PERMIT ISSUED
Permit Number: 060903
JUL 17 2006
CITY OF PORTLAND

has permission to Construct a steel firescape

AT 249 VAUGHAN ST

City of Portland, Maine - Building or Use Permit

FOSS
WELDING &
FABRICATION
STEEL ERECTION

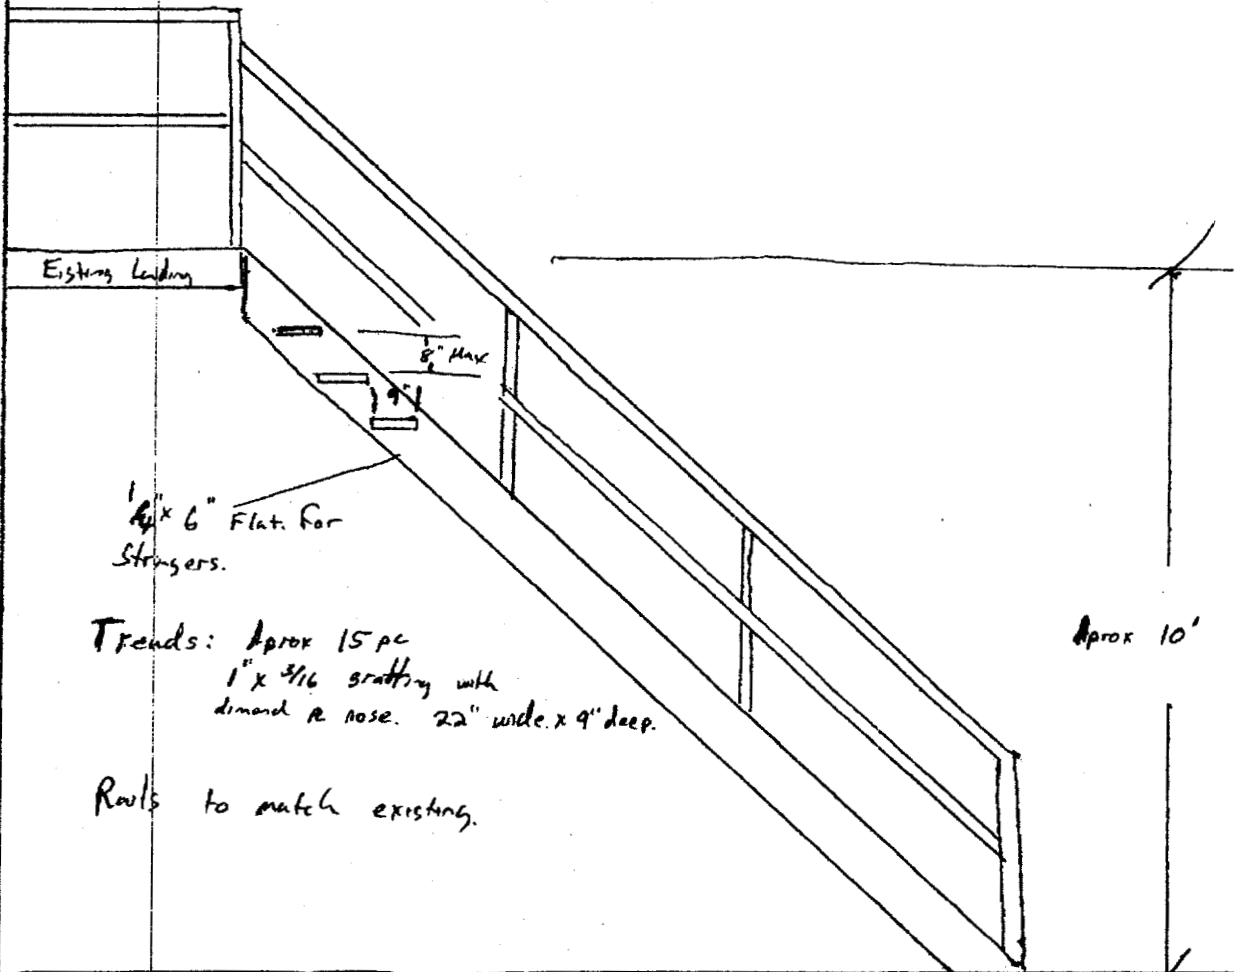
- 1) Guards must be 42 inches in height w/openings less than 4 inches .
2) The Bathroom window must have a 3/4 rating.
3) there must be a landing installed if the vertical run of the stair extension is 12 feet.
- 2) Reviewed as a fire escape in accordance with Section 3404 and Section 3407 (historic buildings)
